Appeal Decision

Appeal Ref: APP/R5510/D/25/3363560

15 Rushdene Road, Eastcote, Hillingdon, HA5 1SW

- The appeal is made under section 78 of the Town and Country Planning Act 1990 (as amended) against a refusal to grant planning permission.
- The appeal is made by Mrs Kamini Thayalanayagam against the decision of the Council of the London Borough of Hillingdon.
- The application Ref is 63838/APP/2025/44.
- The development proposed was described as '*Retention of existing front canopy*'.

Revisions			
Drawing Title			
Proposed Ground Floor Plan & Part Elevations

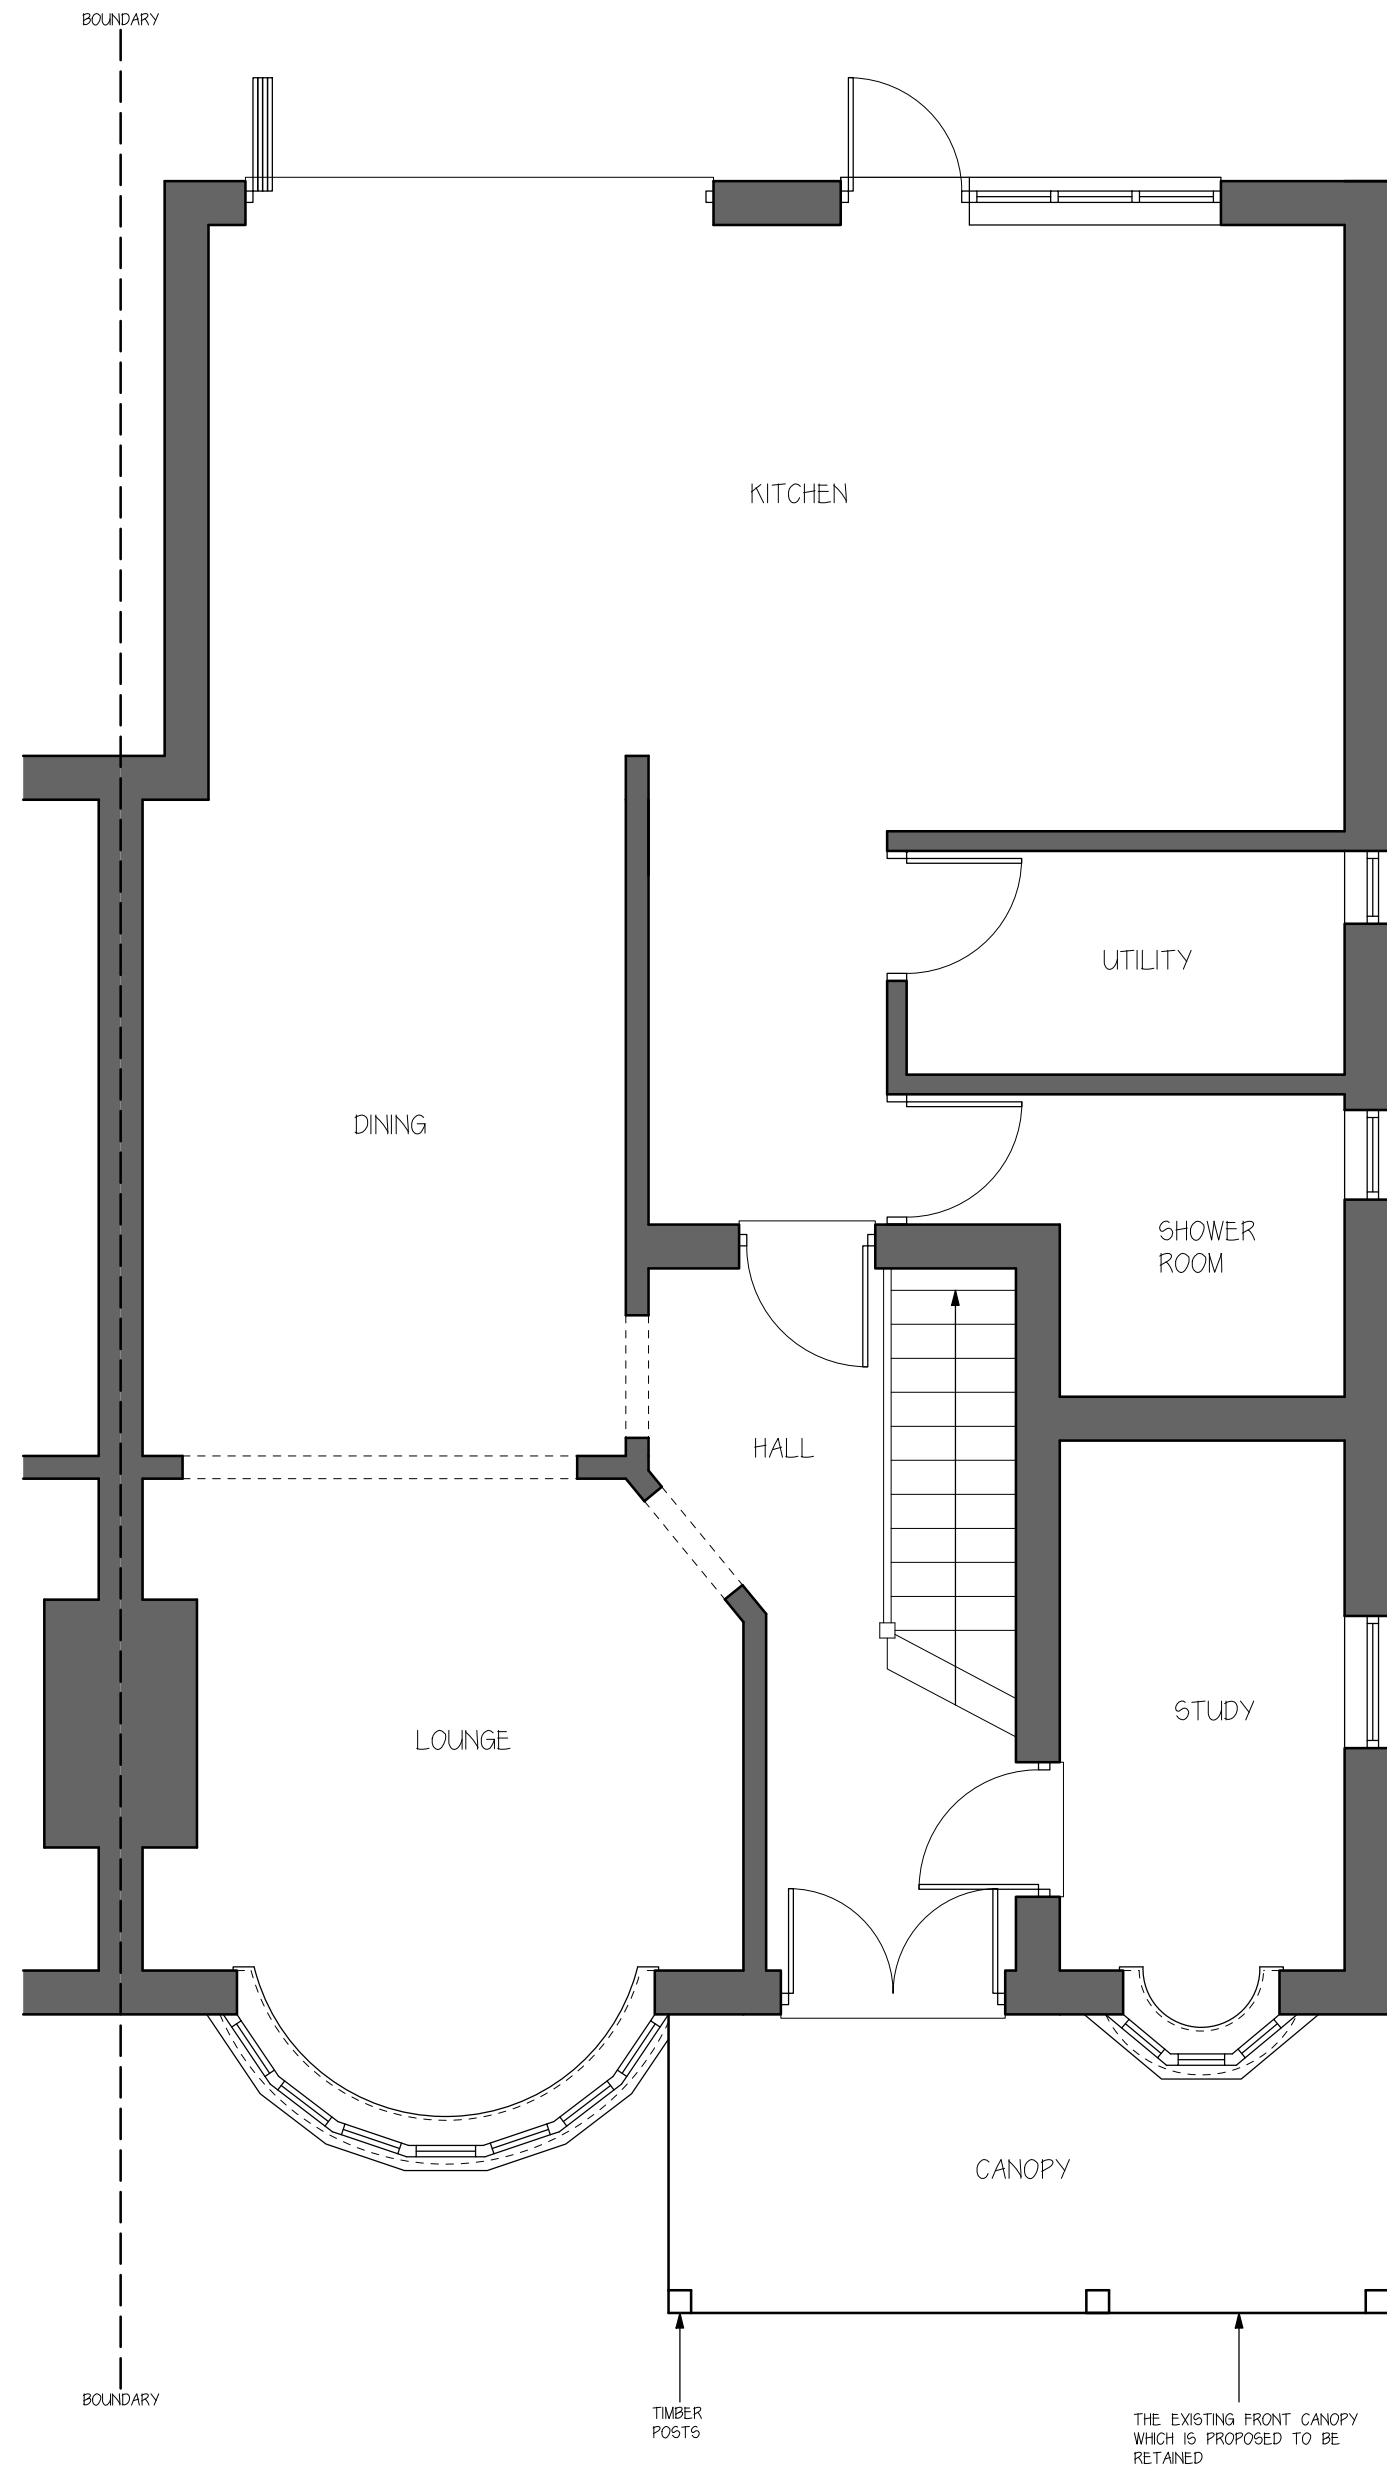
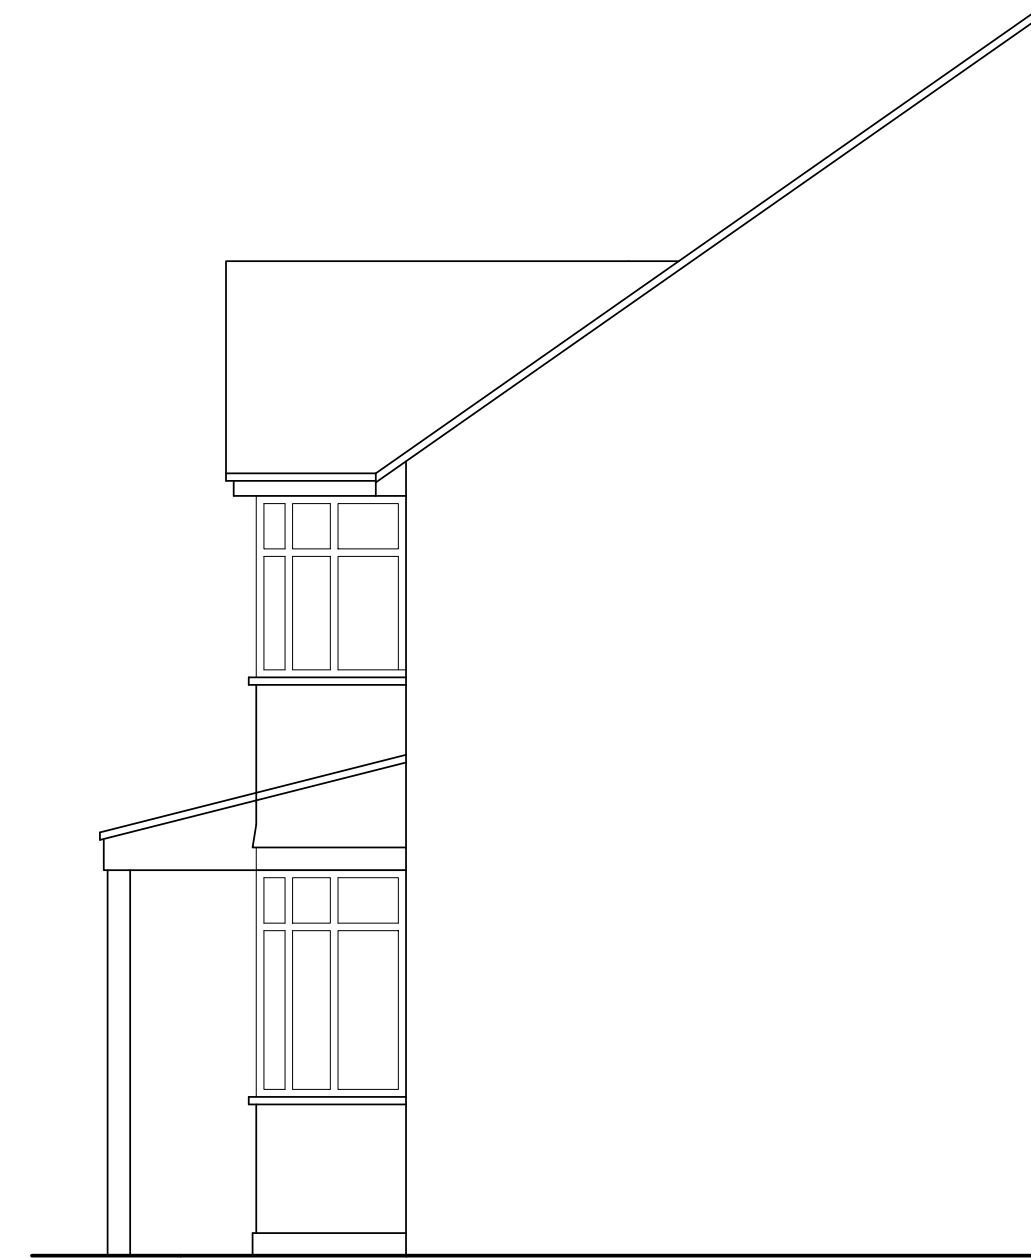
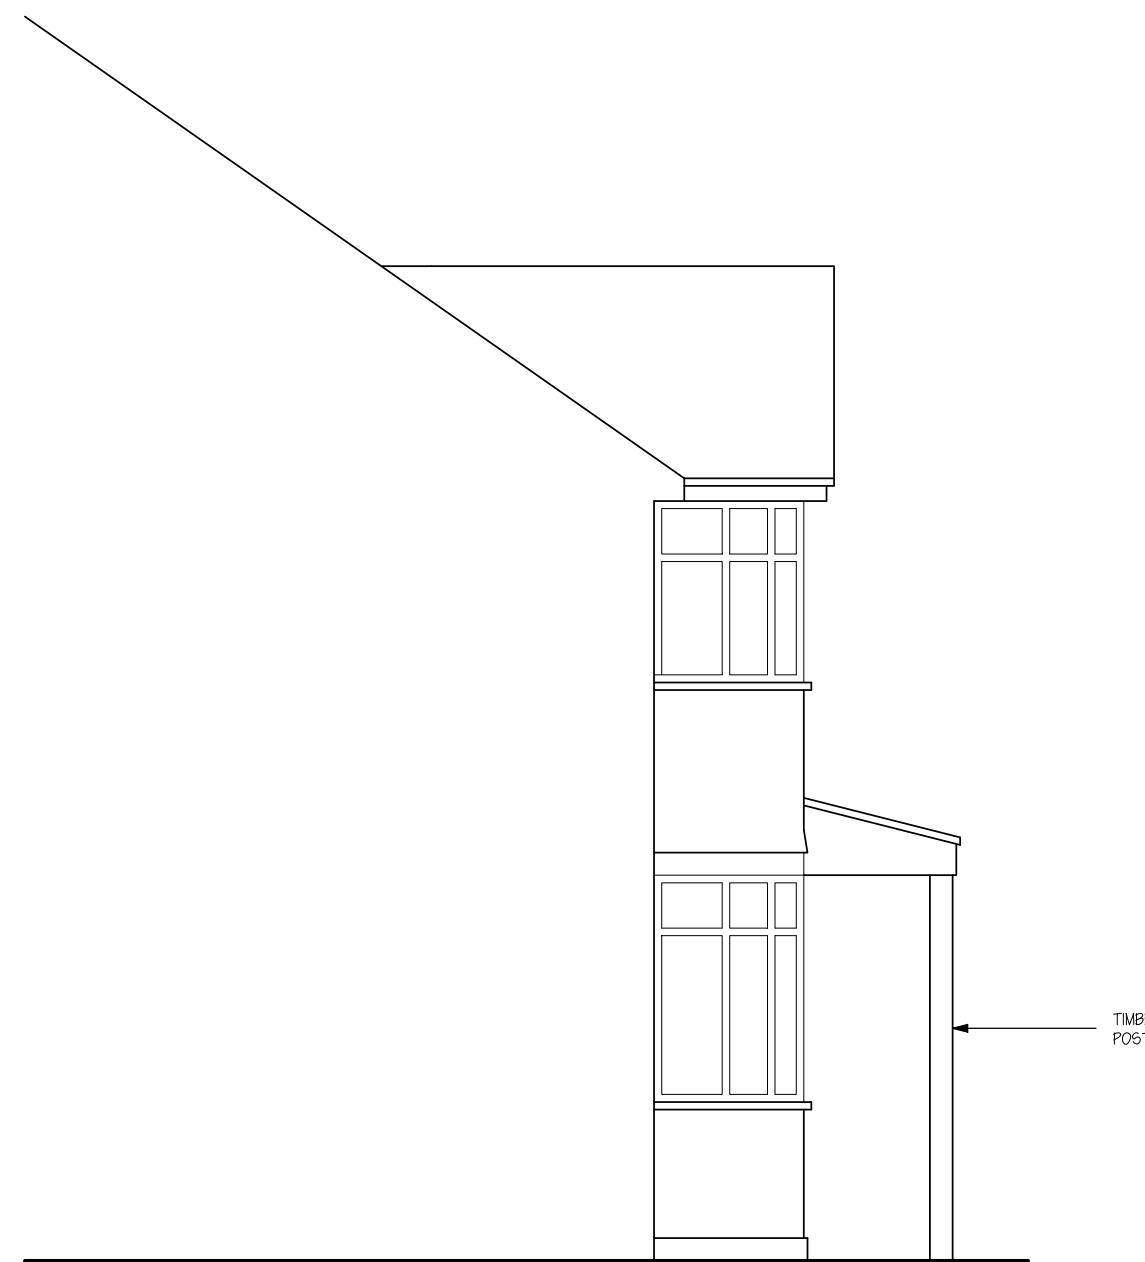
6. The canopy at No 15 is constructed as an open sided timber frame with a lean-to tiled roof over. It projects approximately 2m forward and measures around 4.8m wide, spanning part of the dwelling's original front elevation over the front door and up to the front bay, and across the front of the side extension.

7. Projecting front extensions and porches are not unusual along Rushdene Road. Contrary to the Council's assertions, I found the lean-to roof style to the front of the property to be characteristic of the area; some being original features on some properties with others seen as obvious later alterations. Whilst the style of the canopy at No 15 does not directly mimic the alterations at No 13, I found there to be a reasonably pleasing balance to the semi-detached pair as a result when viewed head-on, including when seen in the vista along The Chase, directly opposite the site.

8. I note the roof tiles used do not match those on the dwelling's main roof, but their red tone complements the dwelling's brickwork at ground floor and is reflective of tile hanging that can be seen on other properties nearby. The colour used is not alien in its setting. The Council correctly observes that the lean-to roof does not integrate with the roof form of the dwelling's side extension. However, the canopy effectively screens sight of the side extension, including its roof. Also given the recessed position of the dwelling, being set behind a hard-surfaced frontage, the relationship between both roofs is not overtly seen from the public domain as visually unappealing or harmful.

9. Overall, I am satisfied that the canopy is appropriately subordinate in scale and respectful of the dwelling's original character. As such I find no harm to the character or appearance of No 15 or the wider street scene. Accordingly, there is no conflict with Policies DMHD 1, DMHB 11 or DMHB 12 of the Hillingdon Local Plan: Part Two – Development Management Policies (2020) which between them, and amongst other things, seek to ensure new development is of a high standard that respects the design of the original property and harmonises with local context. For the same reason I find no conflict with the National Planning Policy Framework's objectives for achieving well-designed places.

1. The appeal is allowed and planning permission is granted for the erection of a front canopy at 15 Rushdene Road, Eastcote, Hillingdon, HA5 1SW in accordance with the terms of the application, Ref 63838/APP/2025/44, and the plans submitted with it.
